Consultation Response from KC, Conservation and Design
2021/94366 Red House Museum, 281, Oxford Road, Gomersal, BD19 4JP
Change of use of existing museum and existing cart shed to commercial short term residential accommodation for holiday letting (Listed Building within a Conservation Area)
Date Responded: 1.3.2023 Responding Officer: Sue Brooks Responding Ref: BHS 2/149

The Coach House

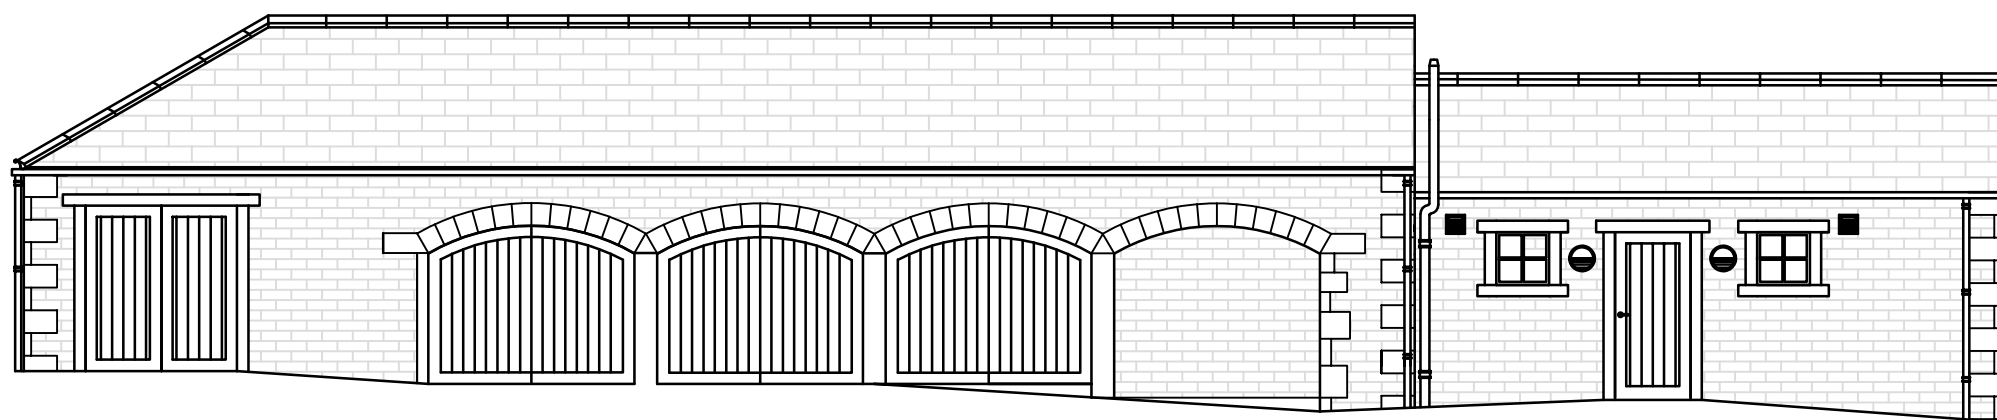
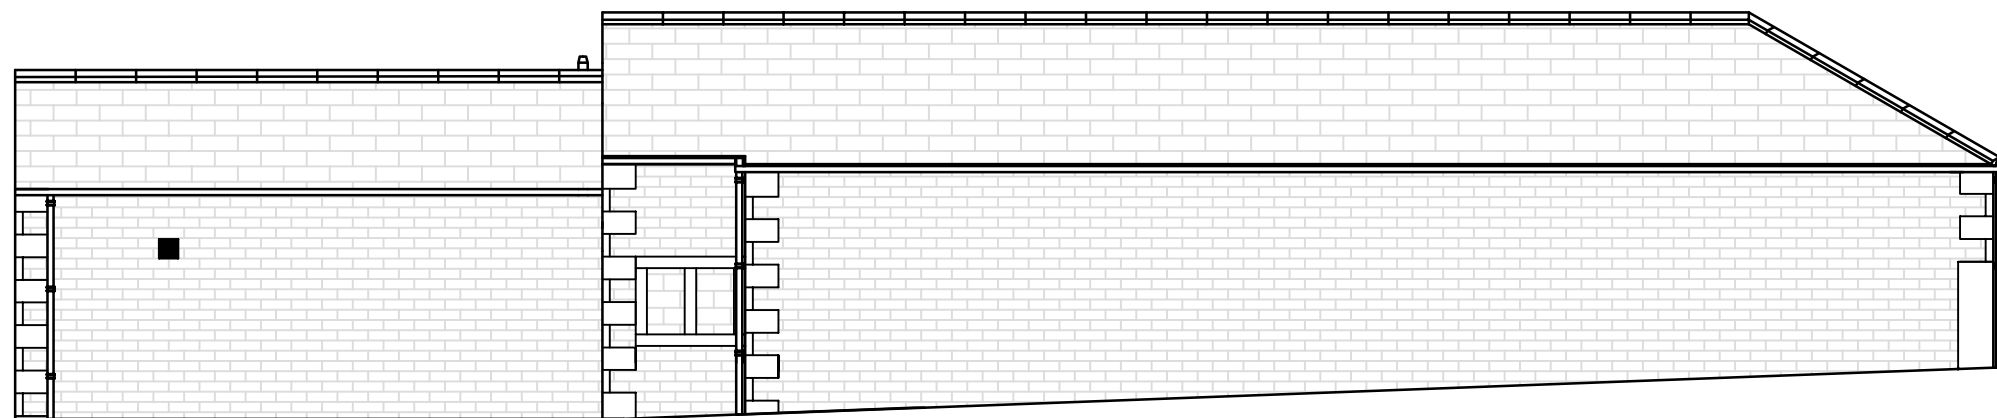
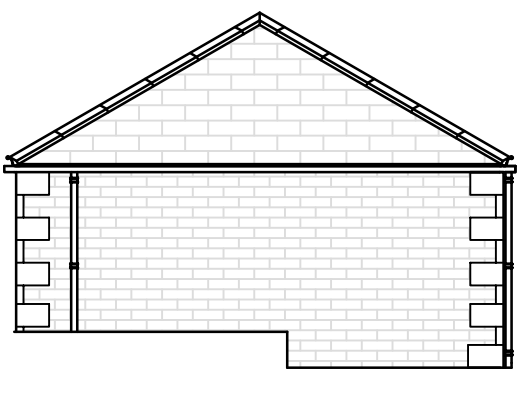
The proposal is to replace the existing timber bi-fold cart doors with glazed screens set into dark frames to minimise their visual impact. The existing doors are recent replacements although characteristic of historic cart doors in terms of design and materials. The introduction of some glazing is accepted to provide natural light within the space with minimal interventions to the historic fabric. However, we would suggest that the screens are re-designed to incorporate timber to allow interpretation of the historic character and function of the cart shed. We recommend that a condition is

applied requiring full details to be submitted for approval and would suggest that the new doorways are set back into the openings, ideally behind the external structure, to minimise fixings into the historic masonry and reduce the prominence of any glazing.

New windows and doors are proposed to the Coach House, and this is acceptable as the existing are not original. A new window opening is proposed to the rear of flat 2 in the position of an infilled opening, and flat 1 which is part of a modern extension.

- No works to install new cart entrance doors or screens in the coach house shall take place until sections at 1:5 and elevations at 1:20 have been submitted to and approved in writing by the Local Planning Authority. The works shall be carried out in accordance with the approved drawings and retained thereafter.

Site Plan - Proposed

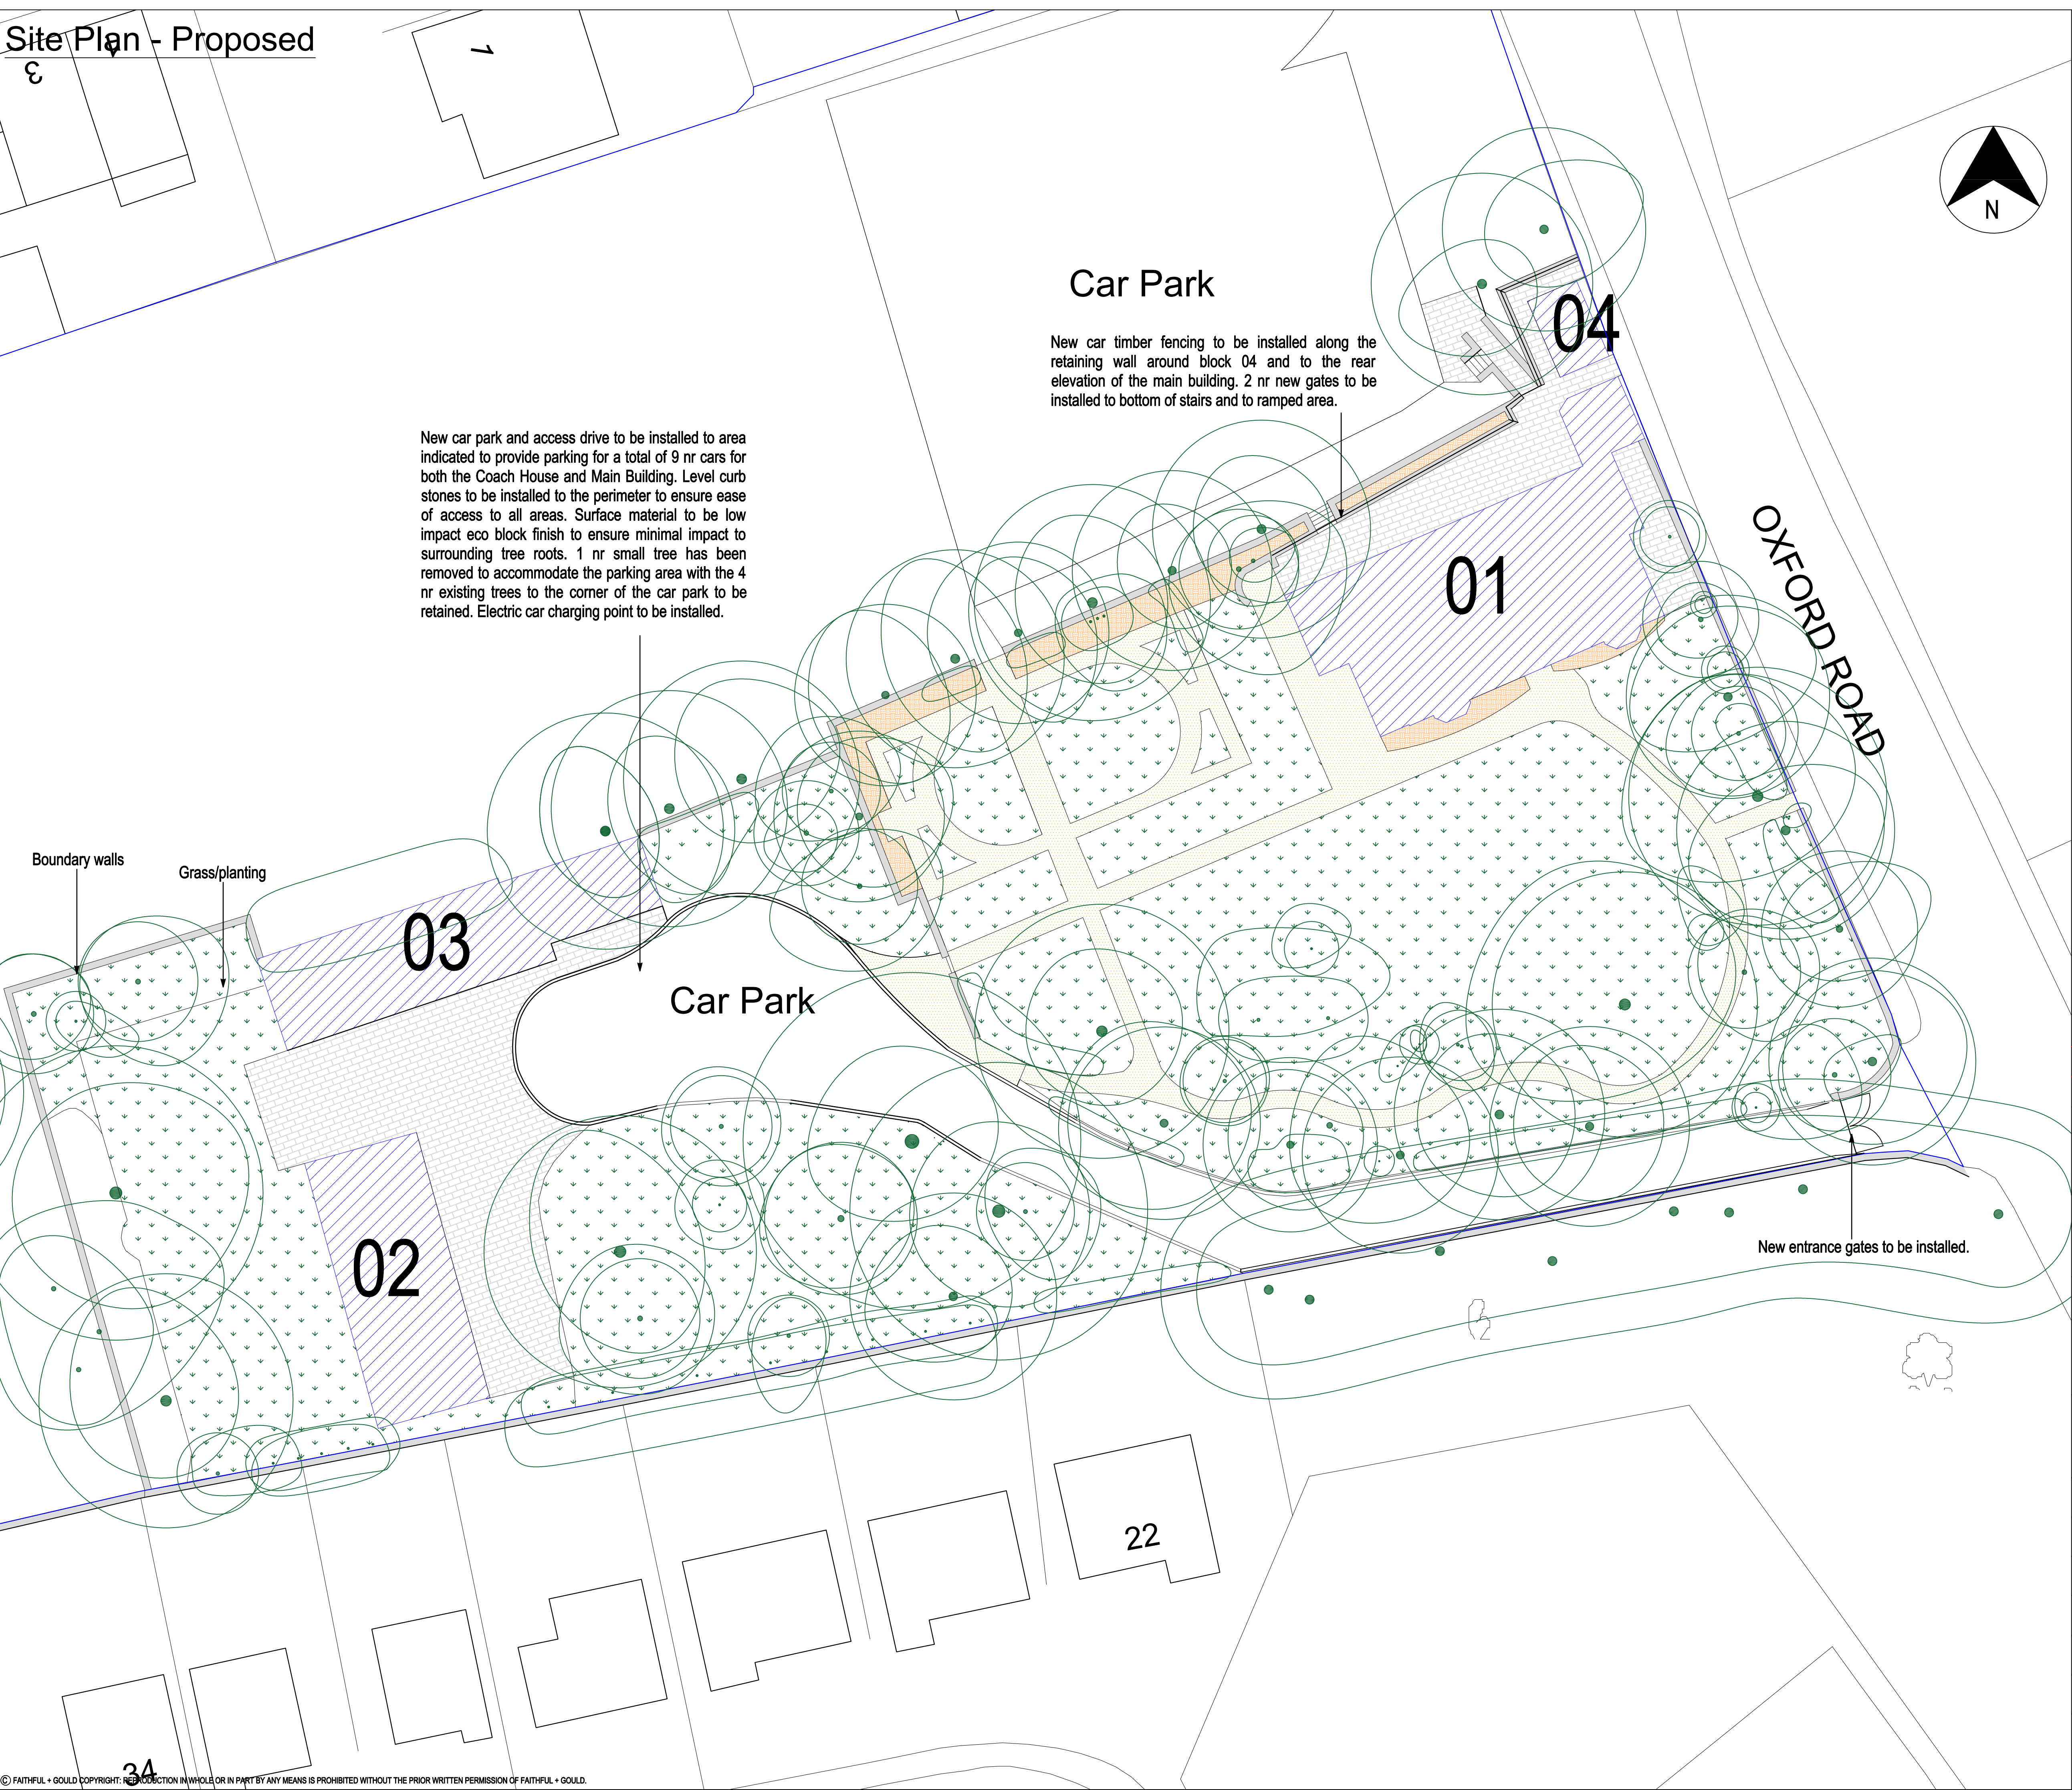
Sensitive landscaping is proposed, with the gravel driveway resurfaced, stone setted area restored and a car park formed between the coach house and garden wall where it is set away from the house and enclosed garden.

- Hard landscaping scheme shall be submitted for approval, including surface types, areas of restored setts, details of proposed entrance gates and boundary treatments, and any alterations to existing boundary walls.
